AQUIND INTERCONNECTOR

Environmental Statement – Volume 3 – Appendix 15.1 Consultation Responses

Document Ref: 6.3.15.1

DATE: 14 NOVEMBER 2019

Figure 15.49: Indicative Landscape Mitigation Plan Option B(1) (south)

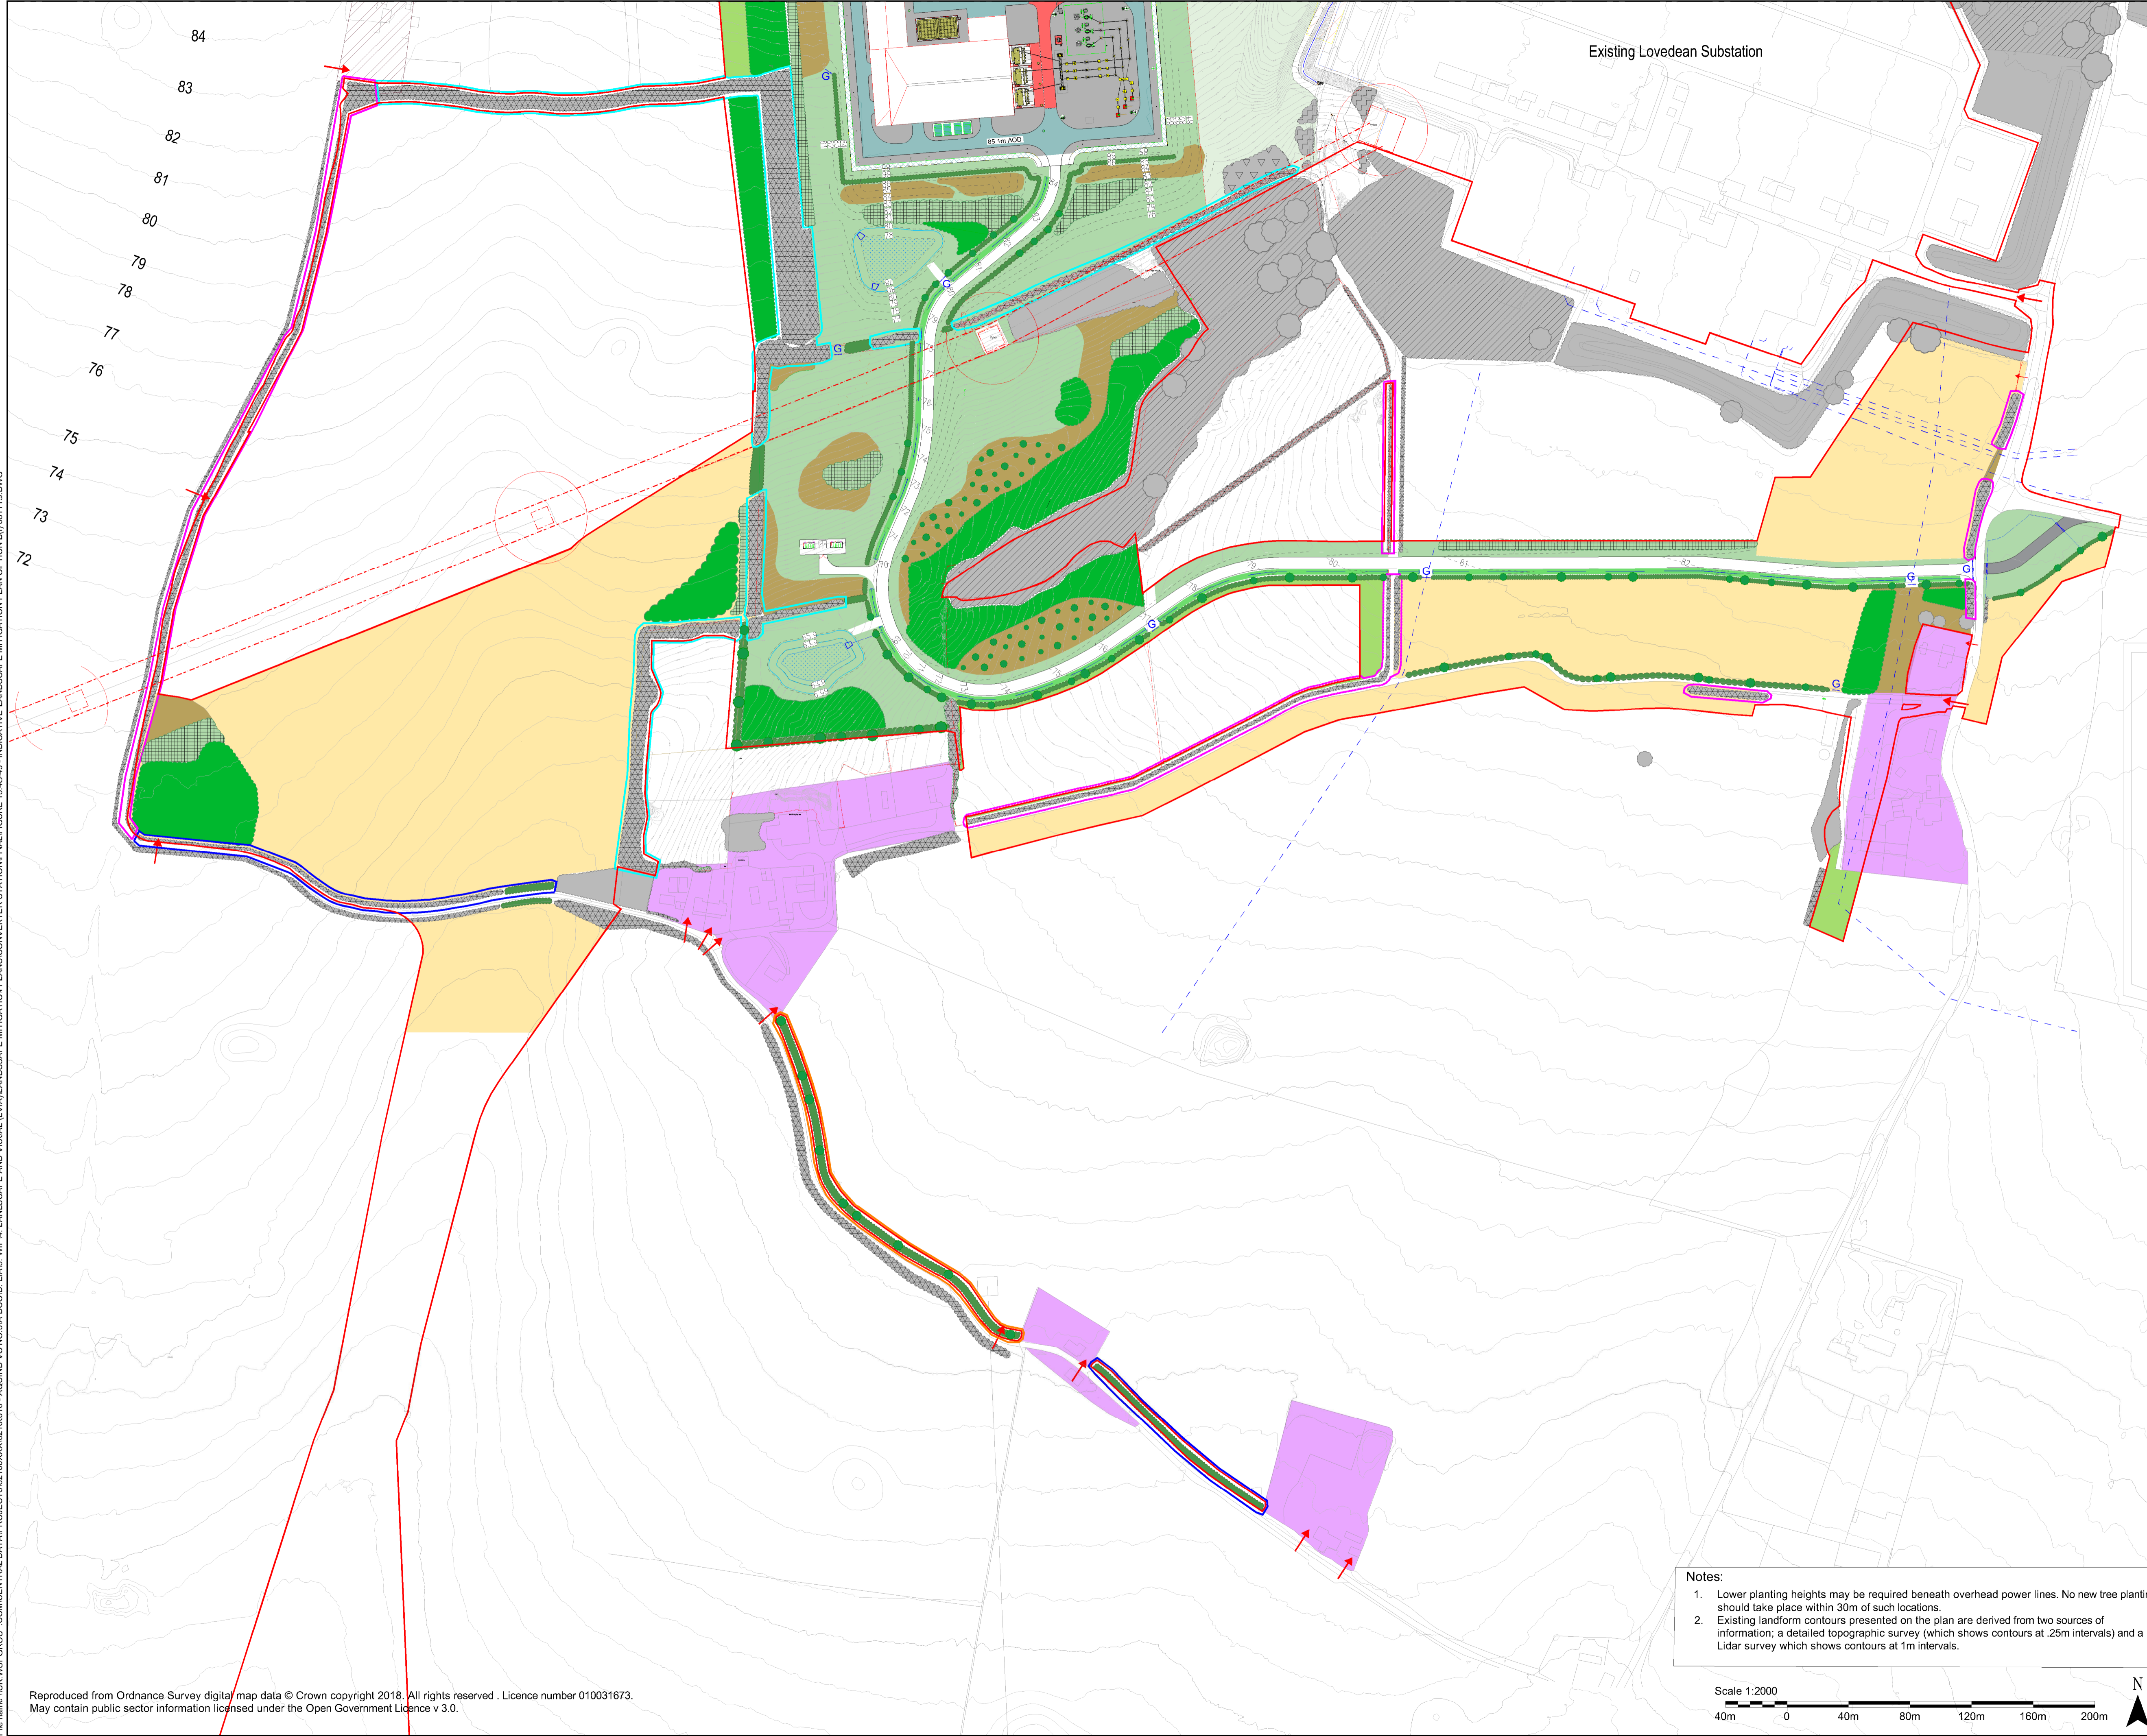
Consultee	Date (Method of Consultation)	Discussion	Summary of Outcome of Discussions
	design meeting)	of residential receptors to the Converter Station and associated mitigation proposals, retention and gapping up of existing hedgerows/hedgerow trees, preparation of indicative landscape mitigation plans, access track and confirmation that views of the Converter Station would be limited from agreed long distance views. Discussion over the design of the Converter Station covering profile, materials, colour, angles and cladding.	the architectural plans for discussion.
PCC (Landscape)	6 July 2019 (Site meeting with representative landscape officer)	Clarification of viewpoints and visualisations and mitigation requirements	Inclusion of five verified baseline photographs with two wirelines, preparation of an indicative landscape mitigation plan and supporting images demonstrating the mix of planting including hedgerows and tree planting following the line of the existing ash tree.

TITLE: Figure 15.50: Indicative Landscape Mitigation Plan (Landfall)

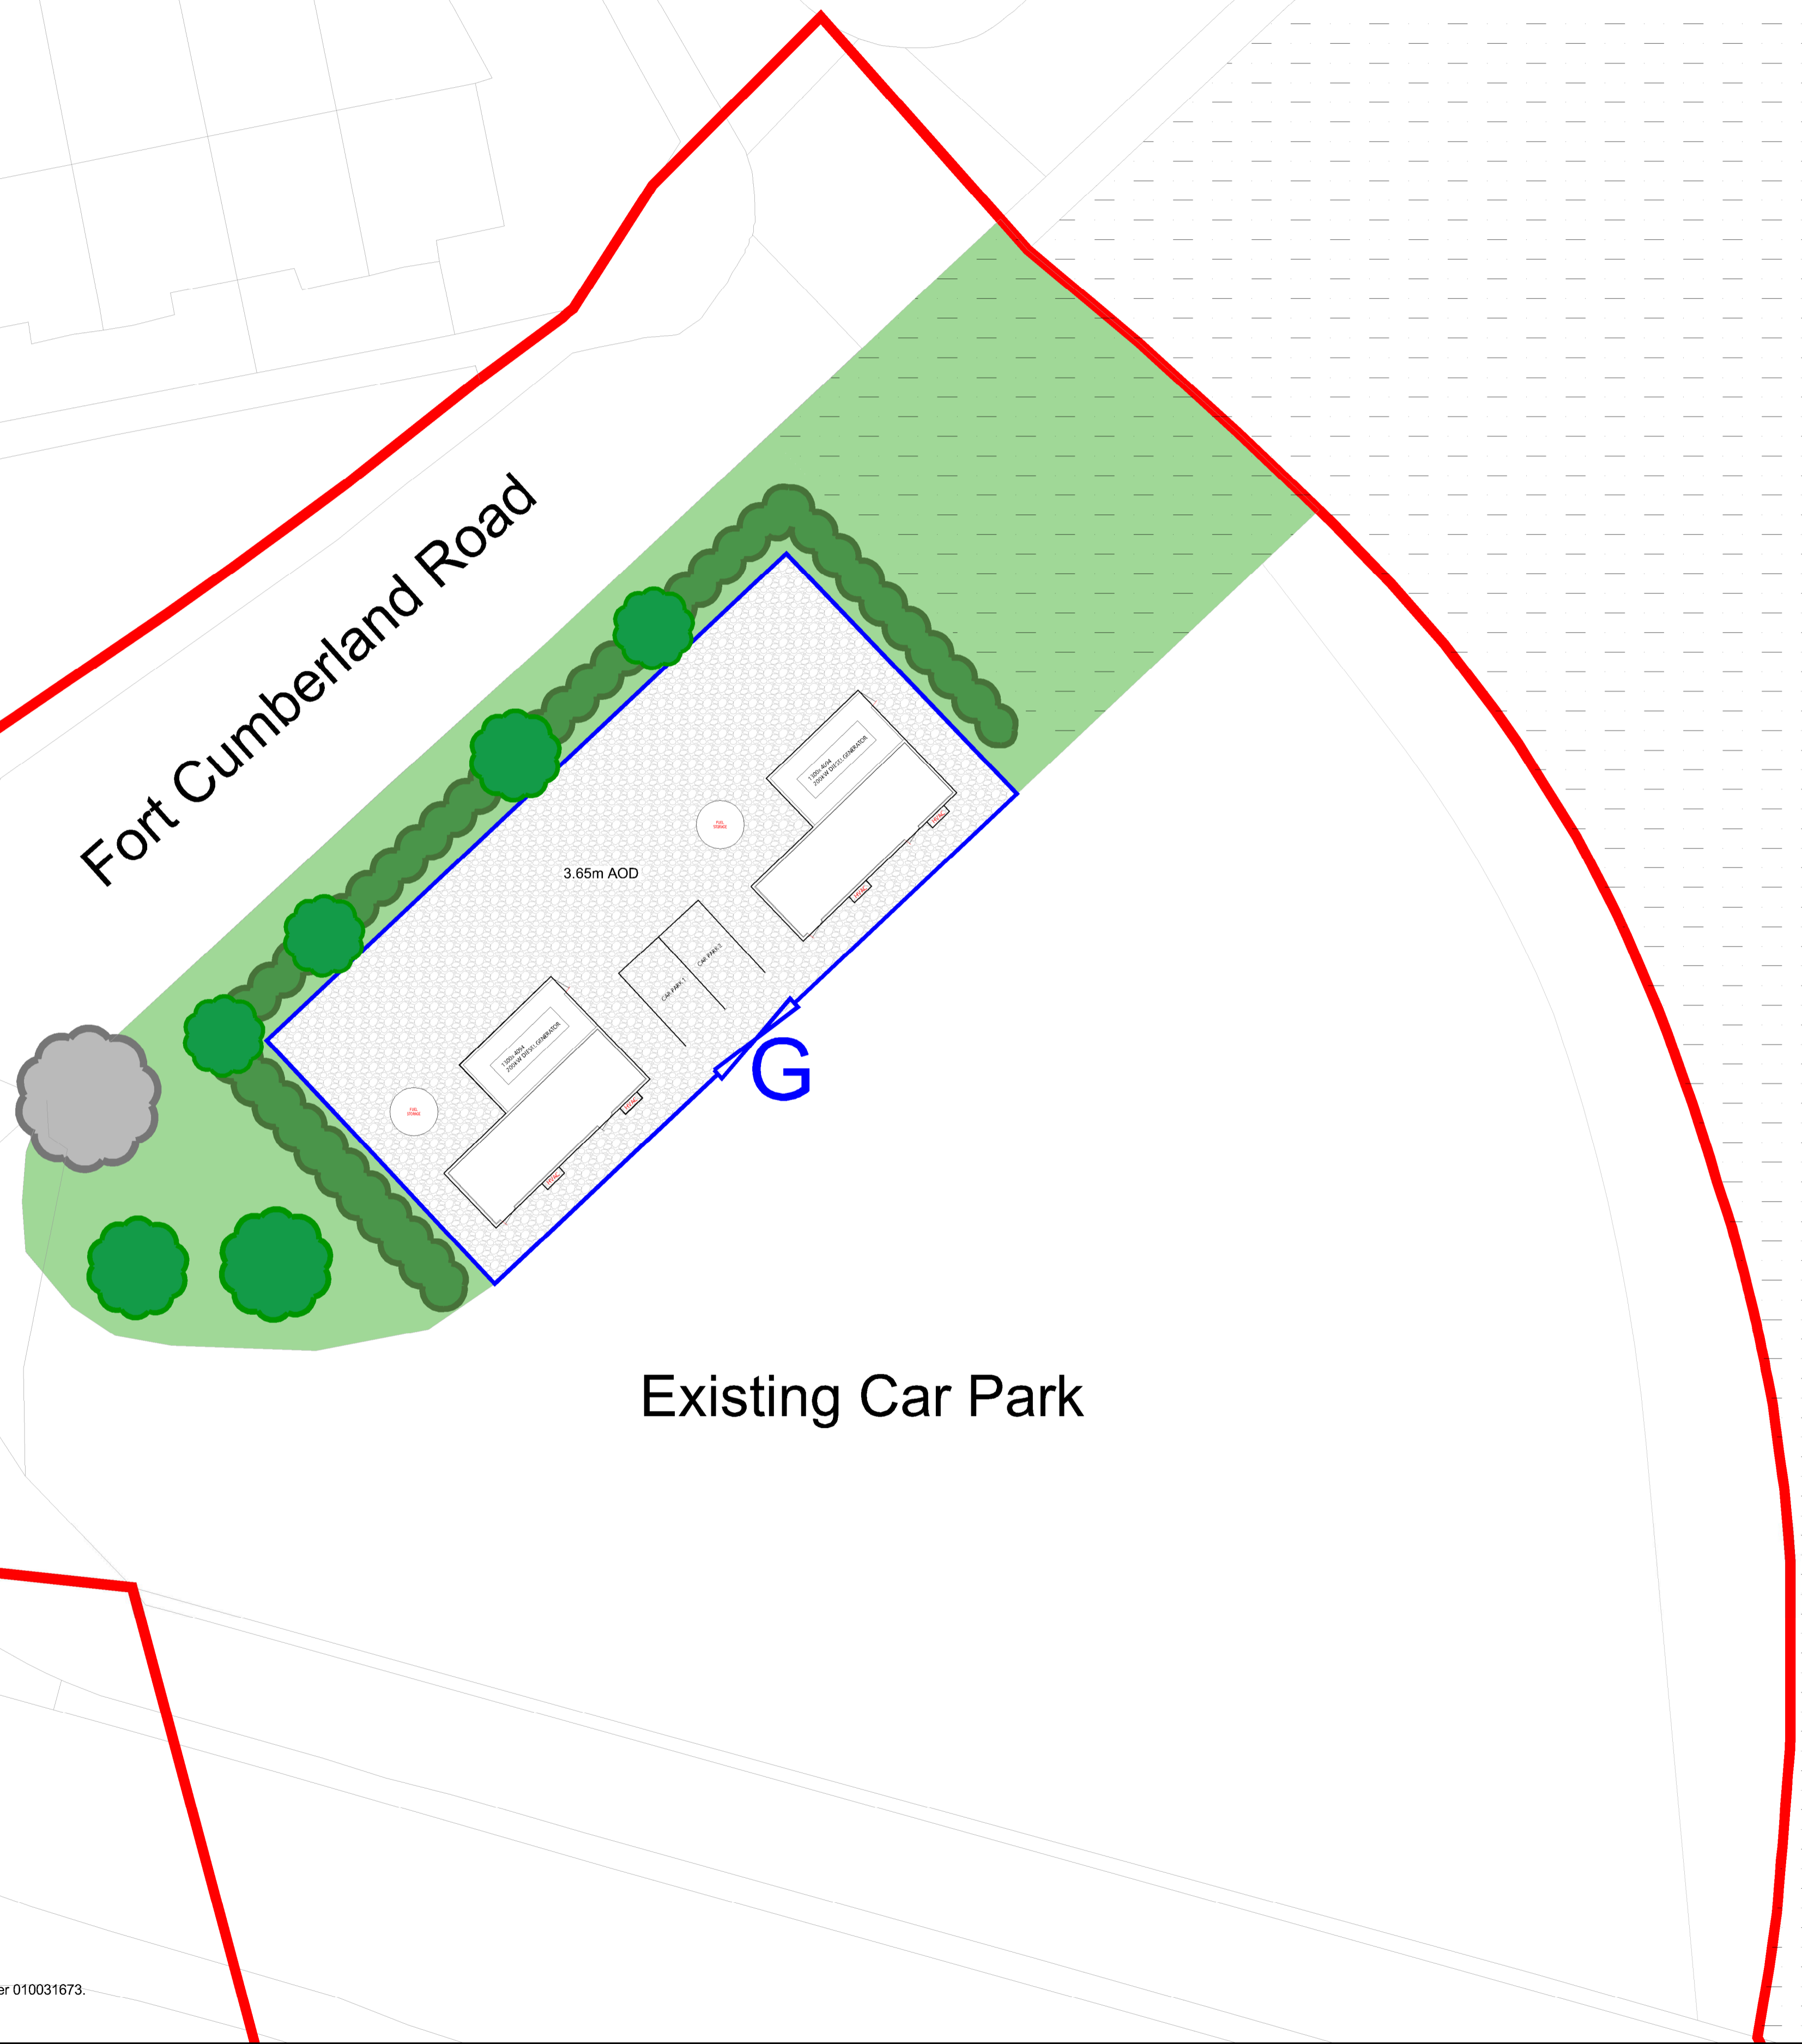
PCC	22 August 2019 (Planning meeting)	An indicative landscape mitigation plan around the ORS was presented illustrating the buildings, compound and potential landscaping as well as “fall” distance from the buildings to accommodate trees for visual screening of adjacent visual receptors.	Parameter plans prepared to demonstrate the parameter envelope of two different options for the ORS within Fort Cumberland car park at Eastney.
